Historic England

5 November 2025

**STONYHURST COLLEGE, AVENUE ROAD, HURST GREEN, BB7 9PZ
Application Nos 3/2025/0747 & 3/2025/0749**

Drawing title
GA Proposed Plan - South Fronts West

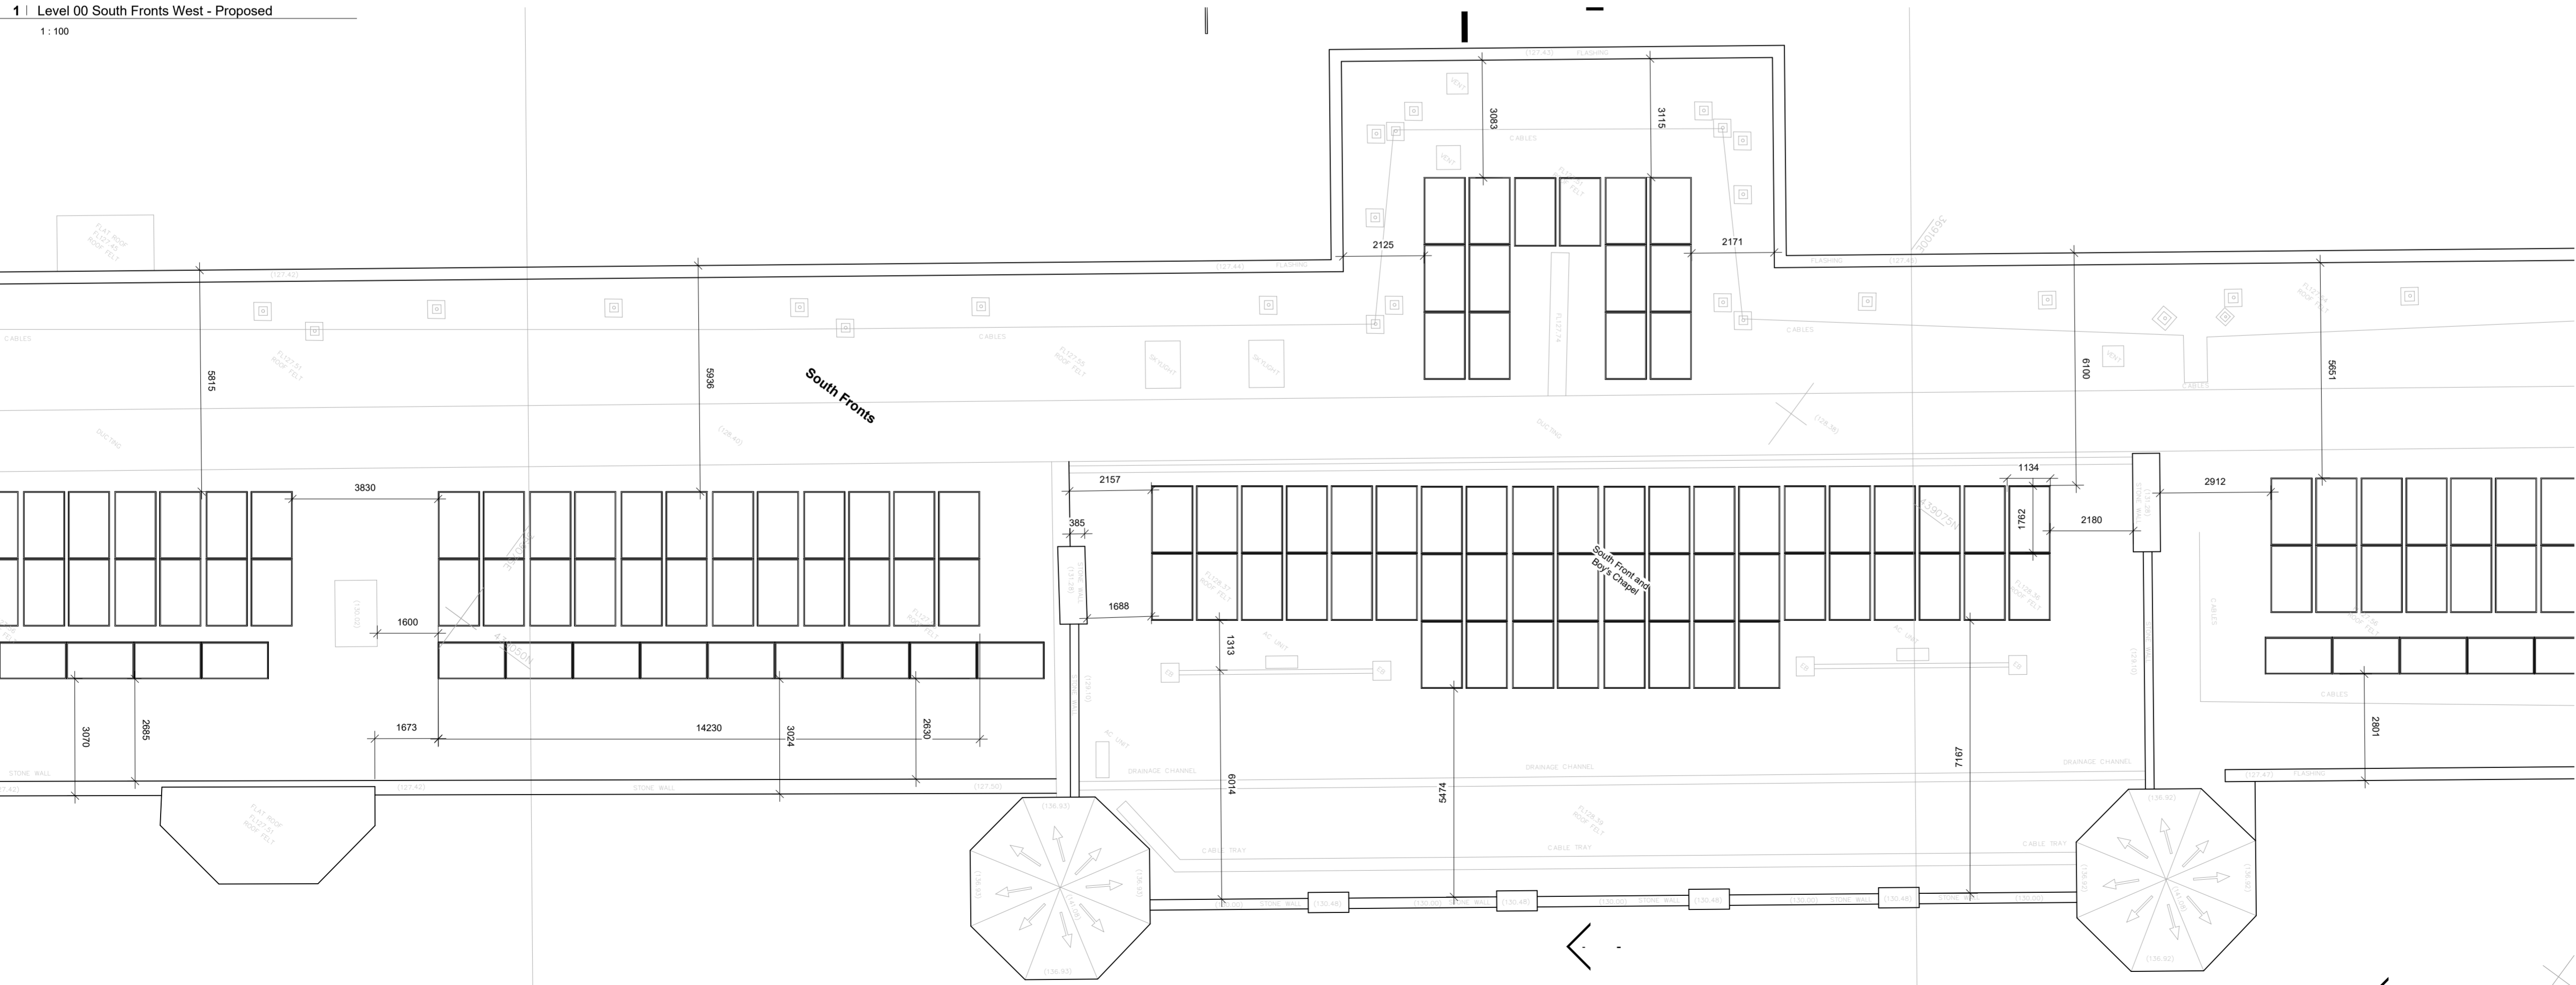
We have some concerns however, over the information provided on the capability of the historic roofs to take the structural load of the panels plus the ballast. A ballast system can be useful as it avoids the need to anchor the panels through the roof into the rafters, which can create a route for moisture ingress. However PV panels plus ballast can significantly increase the overall static load and could risk causing harm to the historic fabric of the building. We advise that a structural engineering report should be provided to justify the types of fixing proposed and confirm that the roof structure is capable of taking the additional load.

We recommend, however, that prior to determination of the application structural information should be provided to confirm that the very significant historic roof structures on the South Front and on the south range of the West Front can take the additional loads of the panels plus the associated ballast.
